Your Ref: OWPC17459
Our Ref: R/30/18/HH 07-02-2018
Please ask for:
Mark Jones

Two storey rear extension & roof alteration
9 Broadmark Avenue Rustington

Drawing Number: 1147.02.c

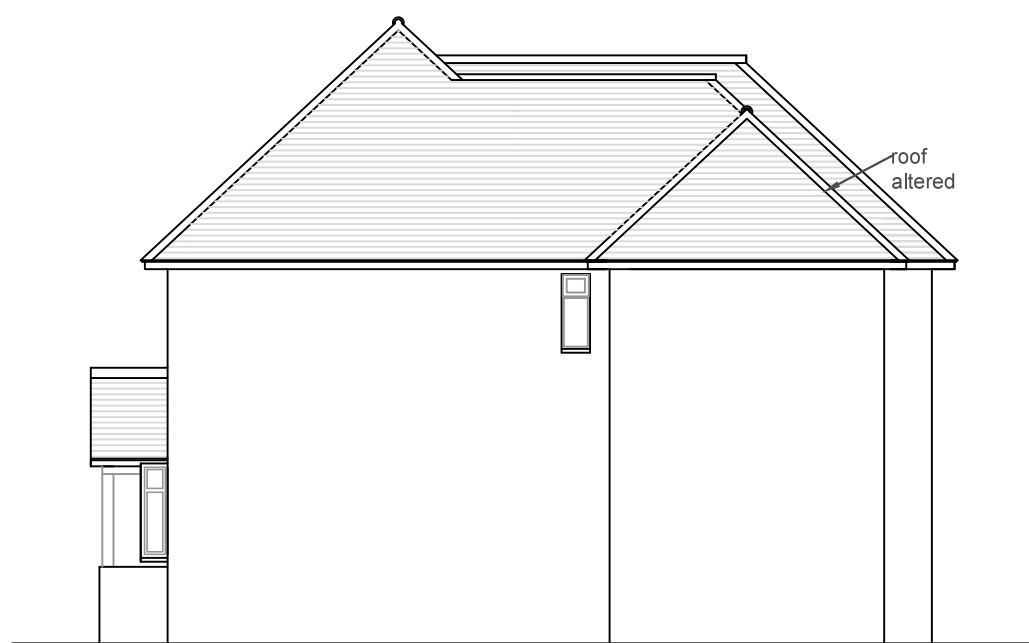
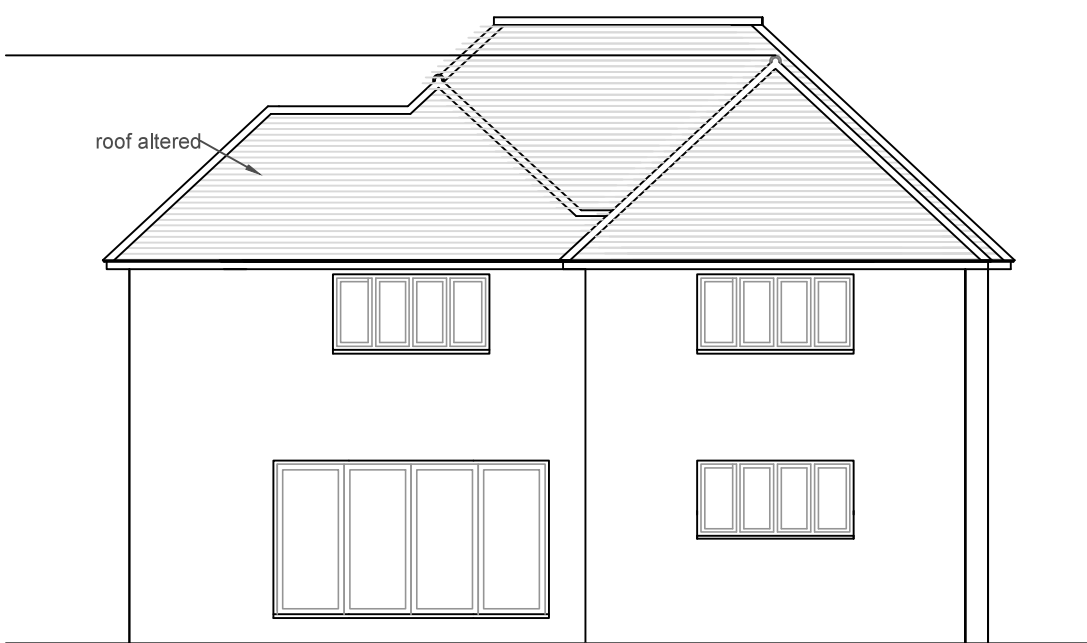
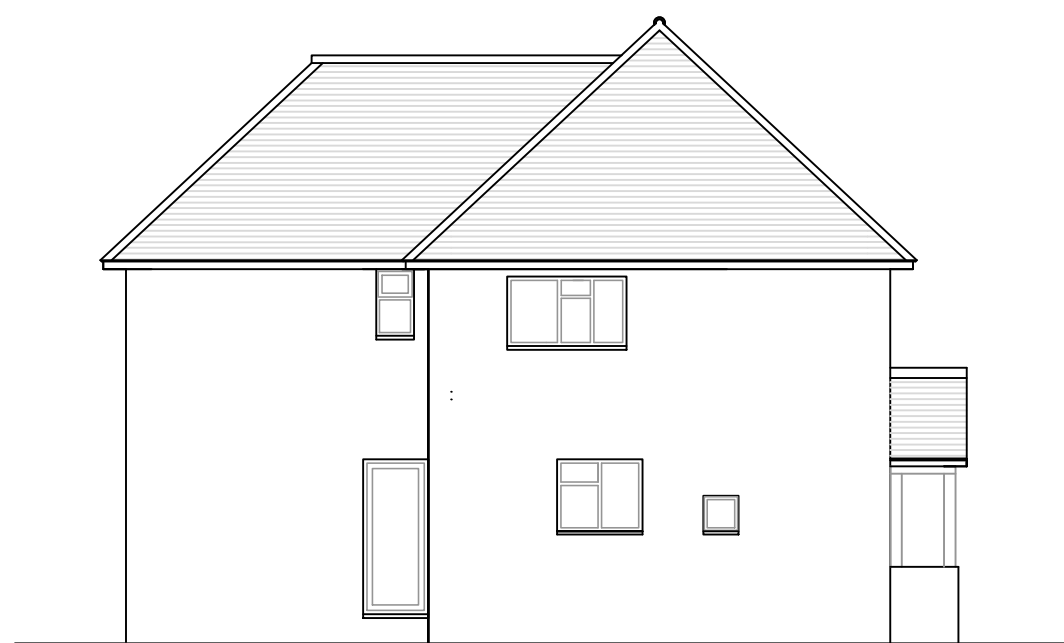
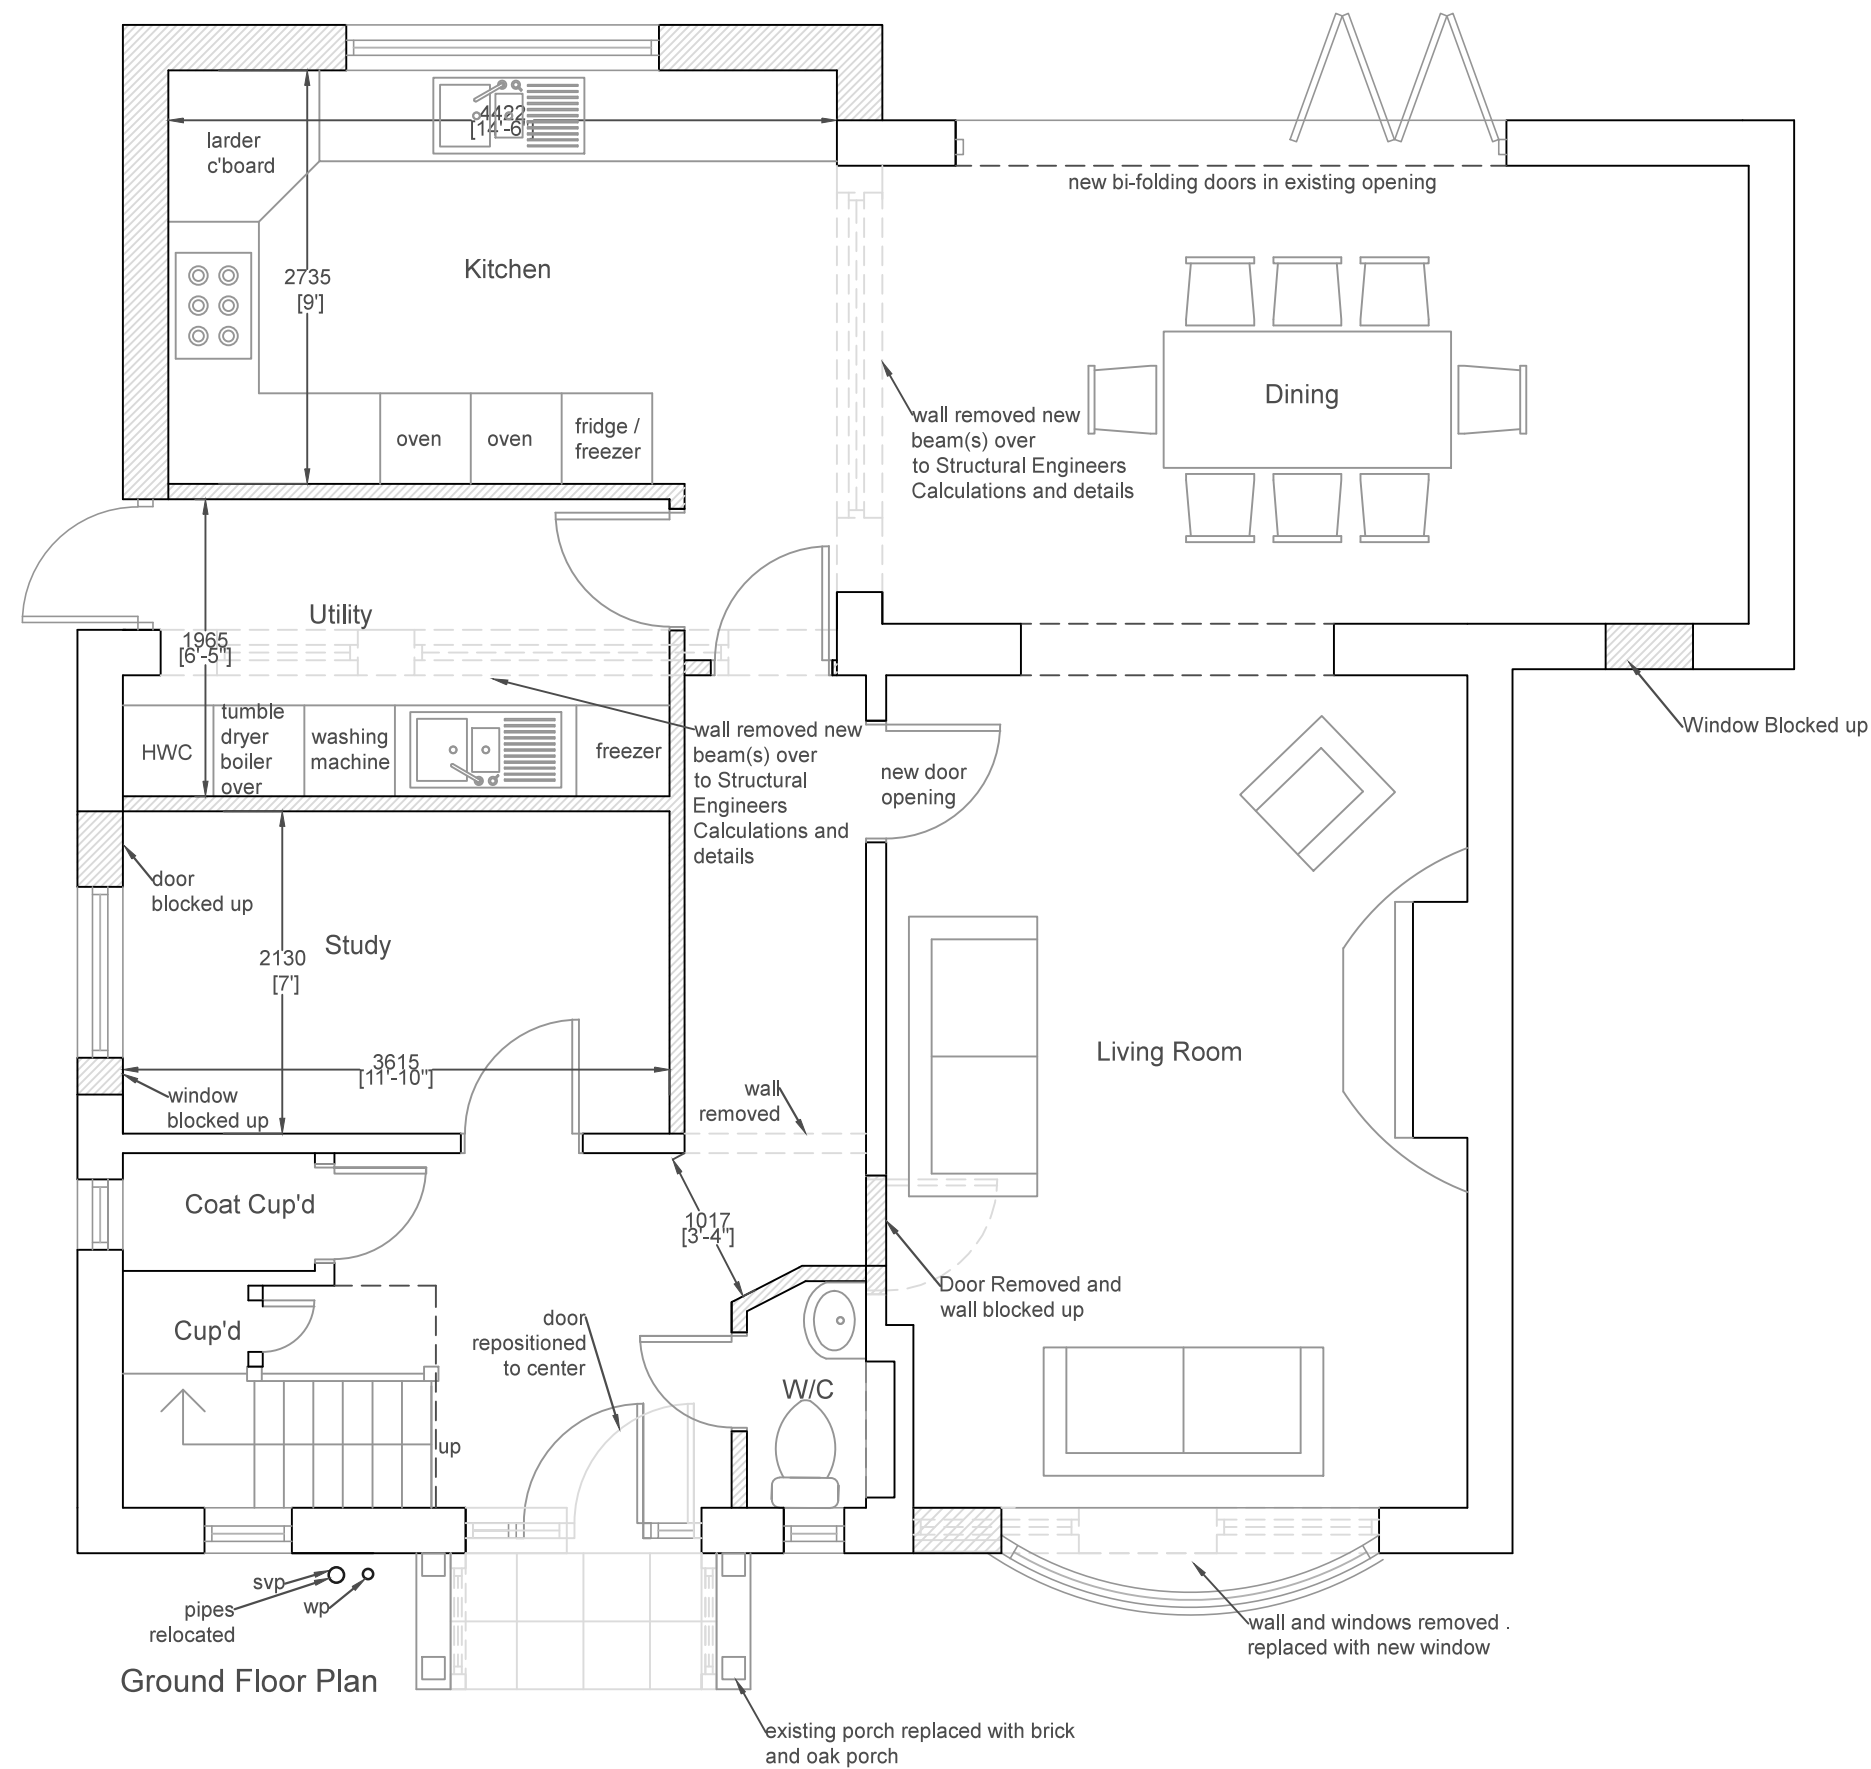
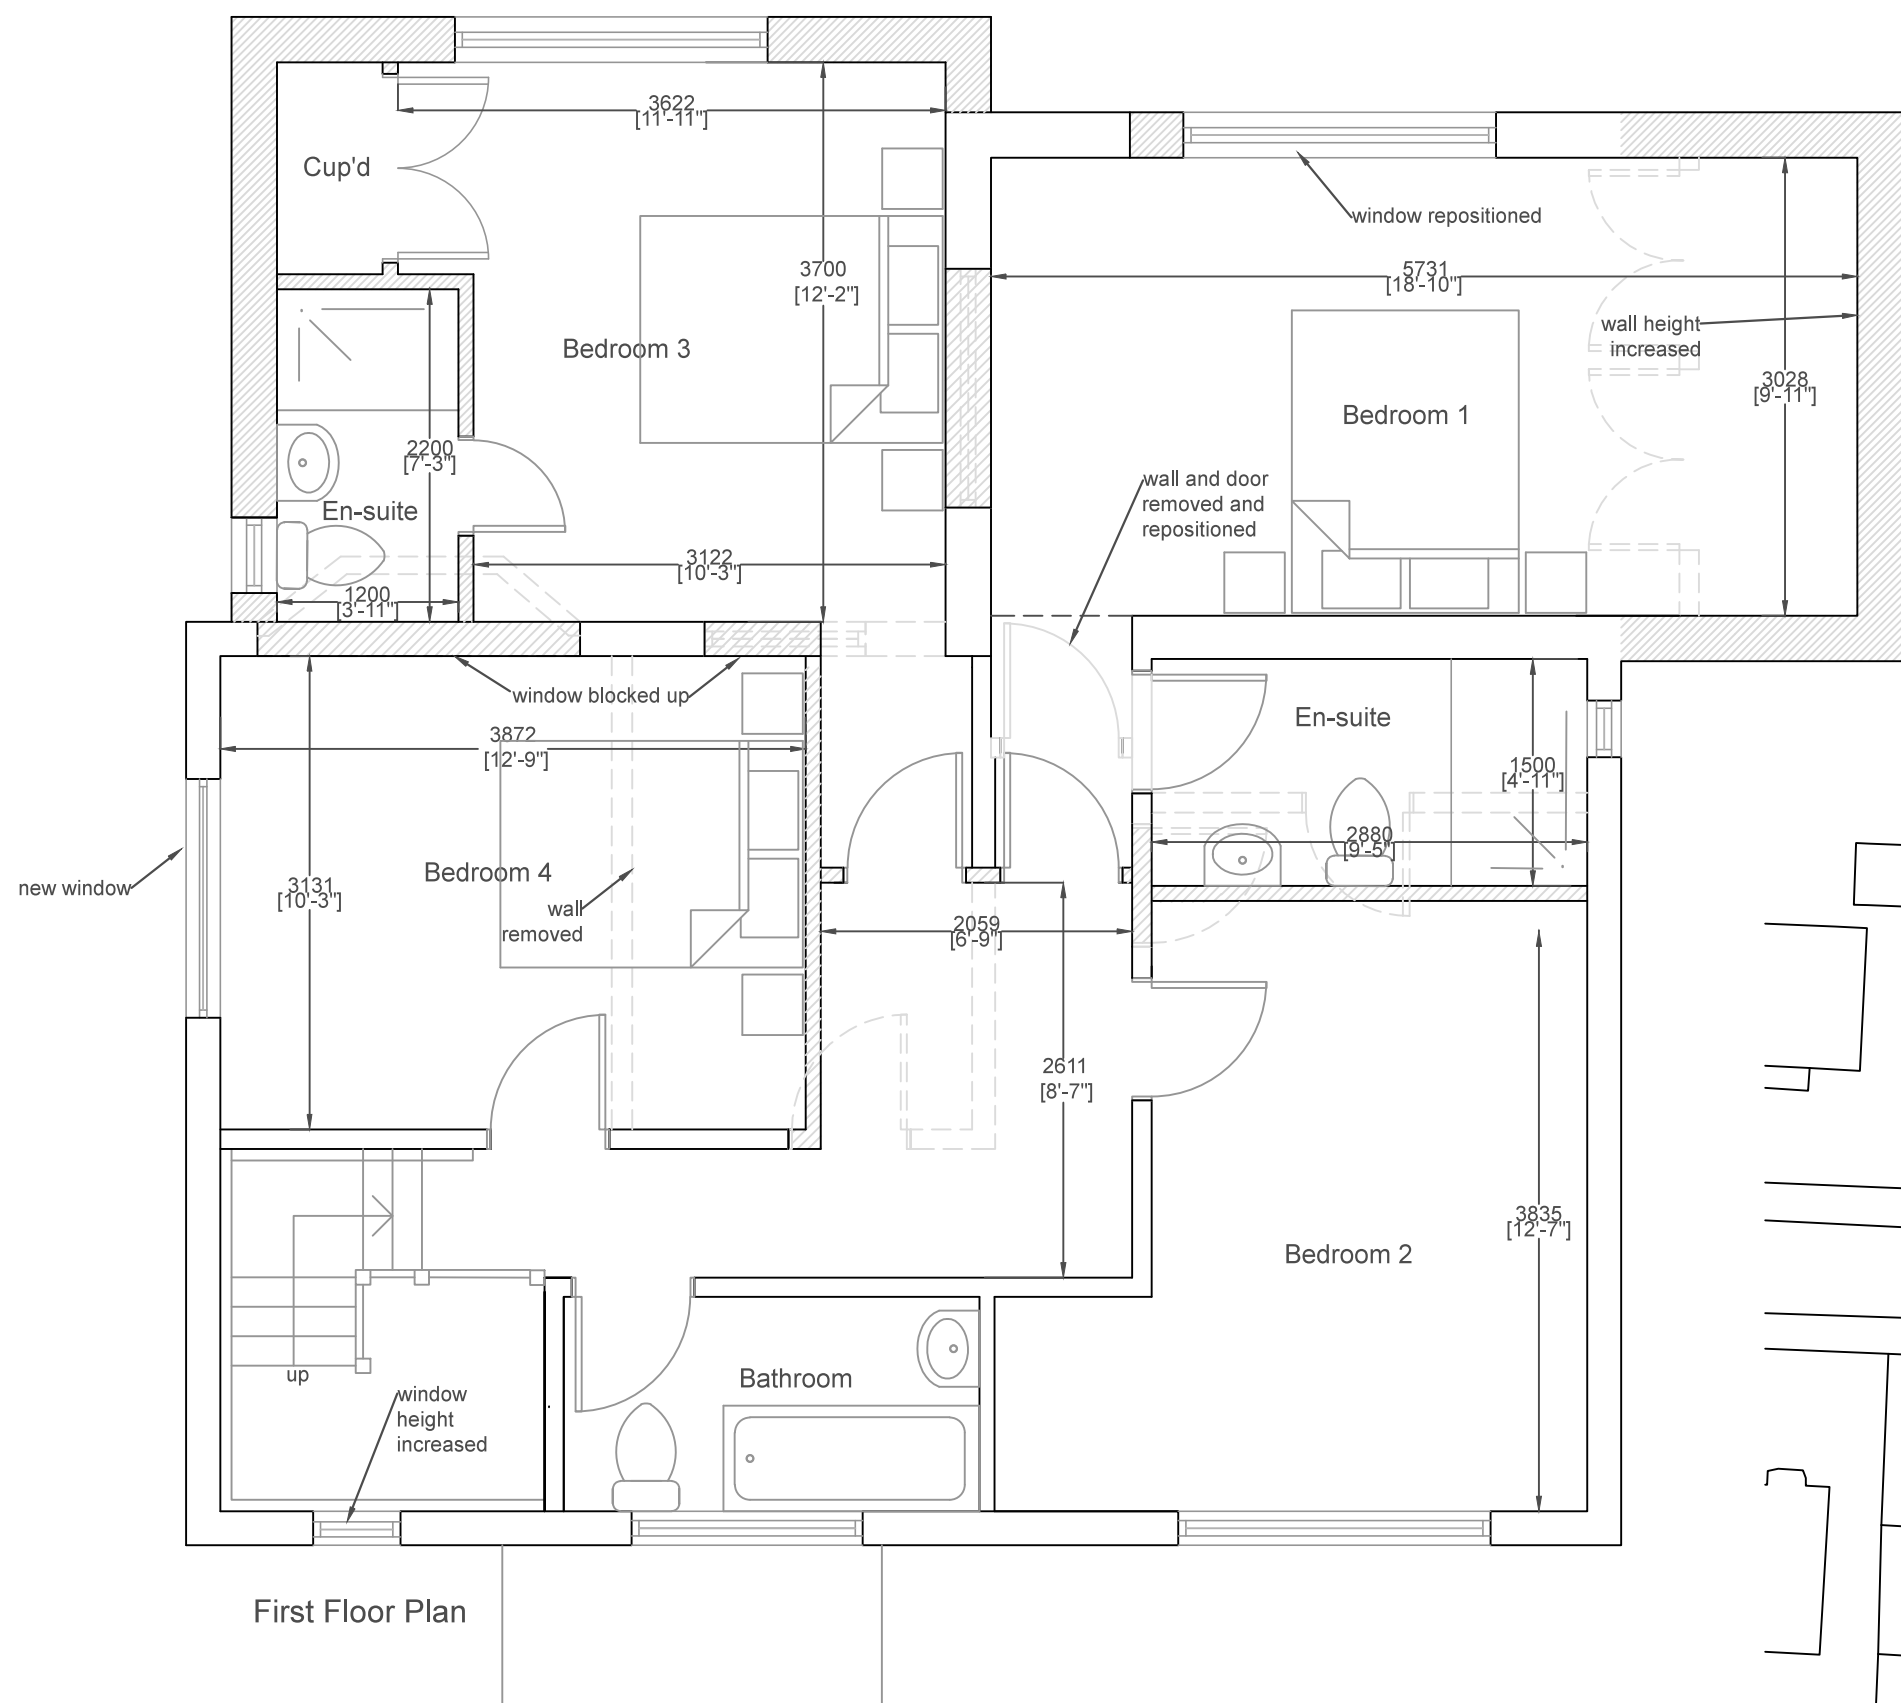
I object to the proposed works to the existing West elevation which would not just alter the roof as noted on drawing No. 1147.02.c but will raise the existing wall by some 1.5 to 2.0 metres and thus increase the bulk of the wall facing my property. This wall is no more than 350mm from the boundary, 1.250 metres from the nearest structure on my property and 3.100 metres from the main building. I consider this proposed work to be too imposing and will possibly cause damage to my property by the increased load from the increase in the height of the existing wall.
